From: [REDACTED]
Sent: 14 February 2022 09:02
To: Planning
Subject: Planning Application No. 3/2021/1160
Attachments: letter of objection.doc

Re: Planning Application No. 3/2021/1160, Owner of 63 Berry Lane, Longridge

Re: Planning Application No. 3/2021/1160
Grid ref. 360265 437507
Owner of 63 Berry Lane, Longridge

I refer to your letter dated 25 November 2021 regarding the above planning application. This letter is a letter of objection made on the grounds set out below. There is no objection made to the proposals for the shop front, refurbishment and re-opening of the former Swifts retail outlet.

PROPOSED ELEVATION E

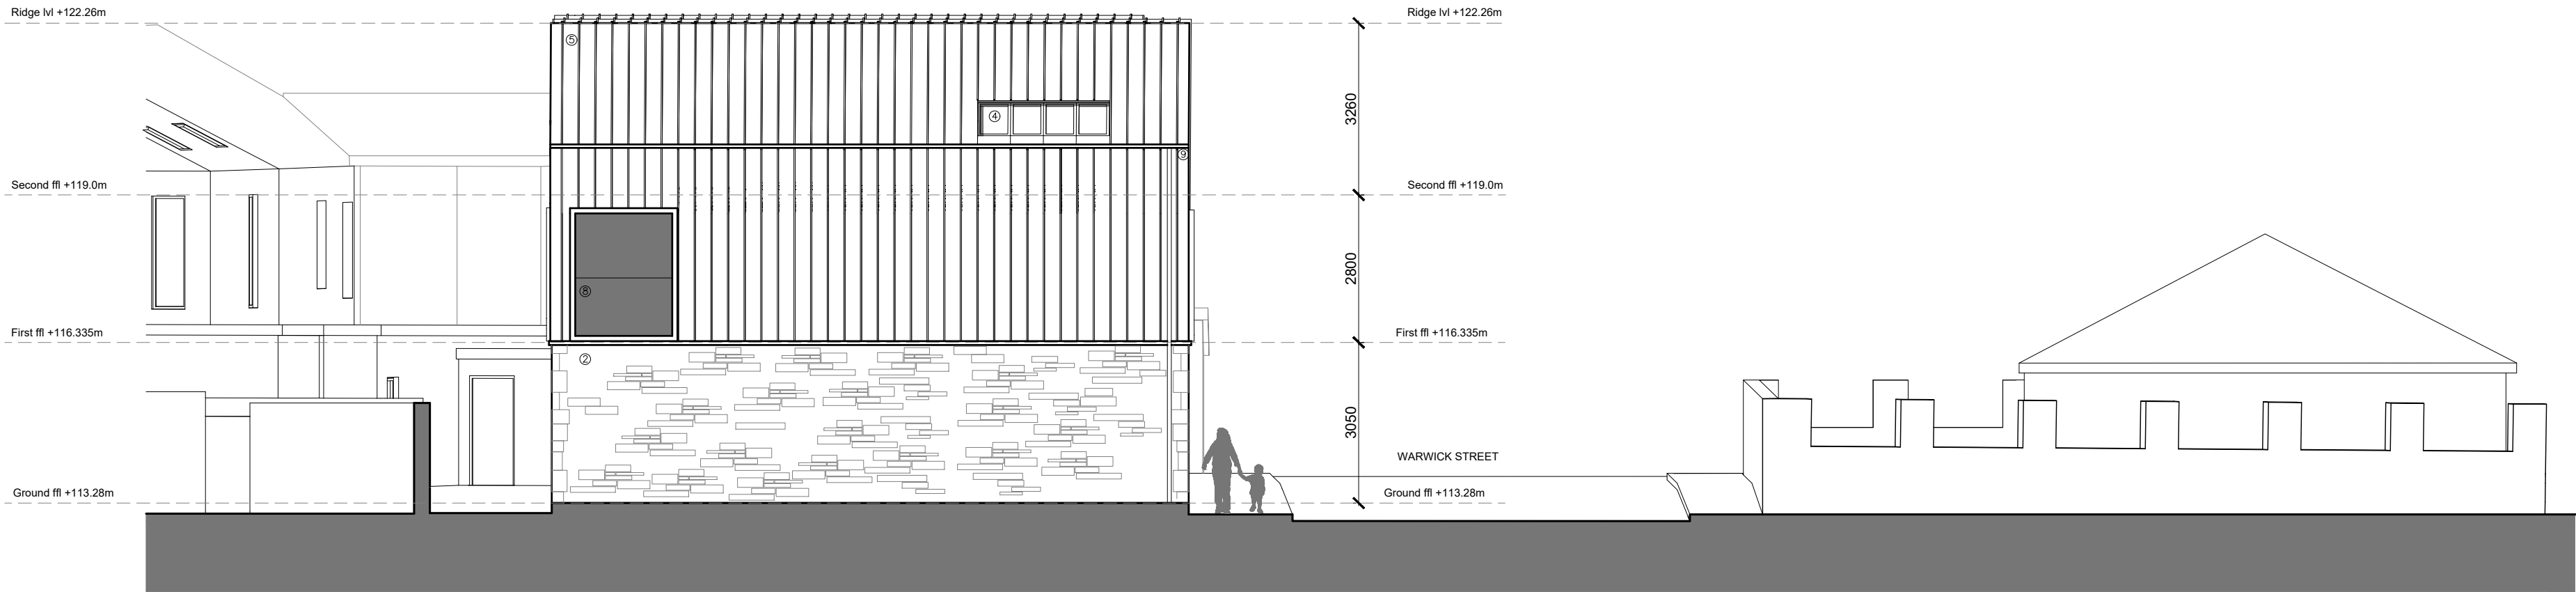
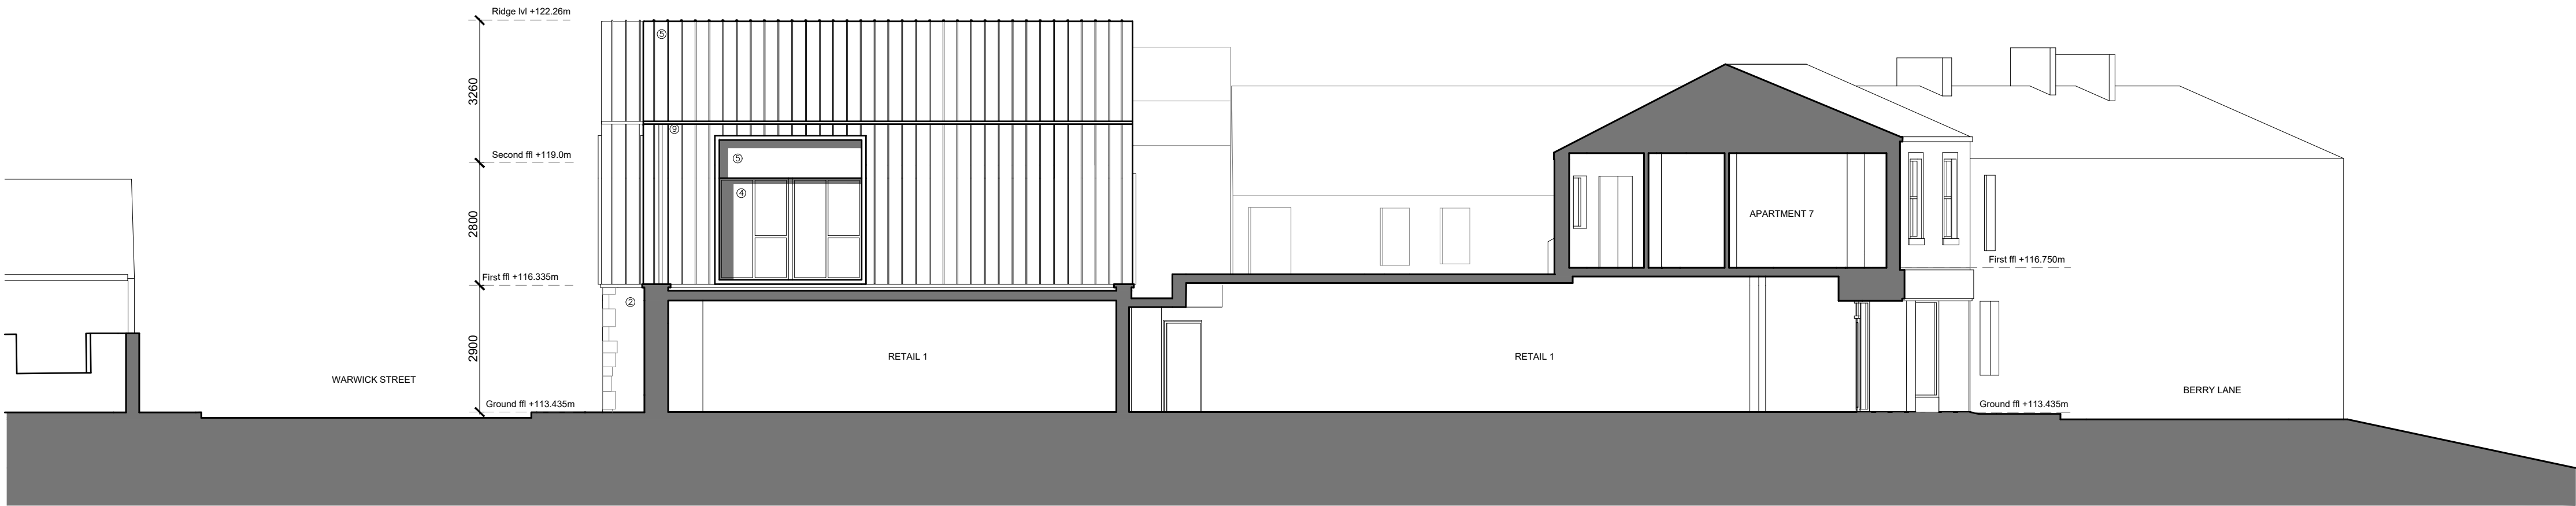
2.1 Given the size and extent of the development it seems grossly excessive both in height (the proposal is for a height at 2.5 stories) and in scale, for the area proposed.

2.2. The height of the proposed development along [REDACTED] appears to far exceed those buildings running along [REDACTED]. The height also impacts considerably the buildings along [REDACTED] behind the development, both in terms of light deprivation and dominance of the development. A great attribute to the amenity enjoyed by the retail spaces, residential areas and yards along the back of Berry Lane is the light and sunny aspect. The fronts of the properties are on the dark north side of the road and so any impact on light and sunshine from the rear of Berry Lane would have significant effect on the overall internal light of the various premises.

2.5 The building materials proposed for the development are not, in my opinion, consistent with the general conservation area and would set a precedent for any future development. It is doubtful that they would stand the test of time and appear to be an attempt to minimise cost.
